Director Infrastructure Projects
 Department of Planning and Environment
 Major Projects Assessment
 GPO Box 39
 SYDNEY NSW 2001

PROPOSED NORTHCONNEX M1 / M2 TUNNEL PROJECT - Application Number - SSI 13_6136
We object to many aspects of this project

MOTORWAY OPERATIONS COMPLEX - SOUTHERN VENTILATION FACILITY - SECTIONS
M1-M2-5000-DR-JD-0525

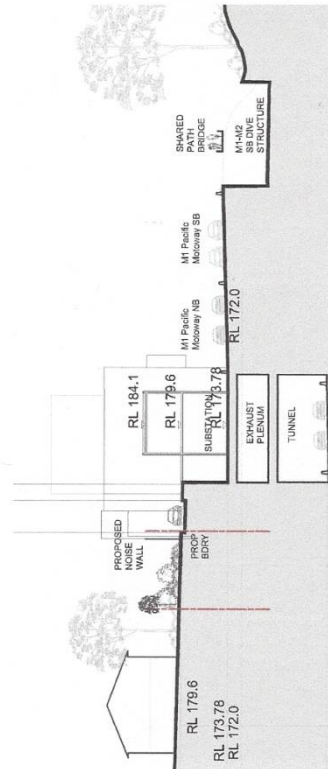
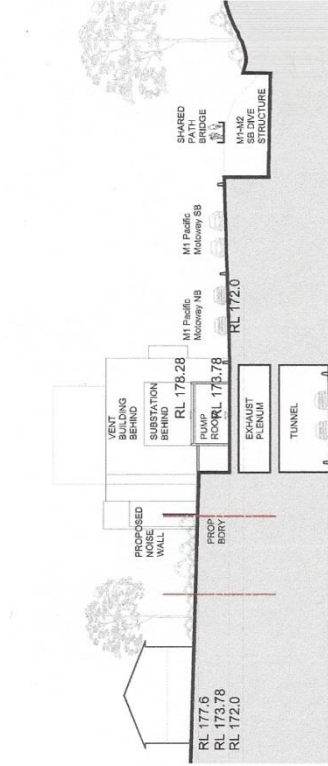
1. The Environmental Impact Statement (EIS) does not show any connection between the ventilation stack and the southbound tunnel which is 250 metres away. Will the polluted air be allowed to flow like an invisible sewer through West Pennant Hills, North Rocks, Carlingford and Beecroft?
ACTION: Provision of diagrams and detailed description of what ventilation is proposed for the southbound tunnel at the Southern Interchange. We would like the opportunity to lodge further submissions once that has been provided.

2. The ventilation stack should be located immediately above the tunnels on the corner of the Pennant Hills Golf Course and the M2. NorthConnex admit that this is the most efficient location for the stack. Why is the stack not being correctly located and positioned as far as possible away from homes?
ACTION: Purchase of golf course land to position the stack in its most effective location.
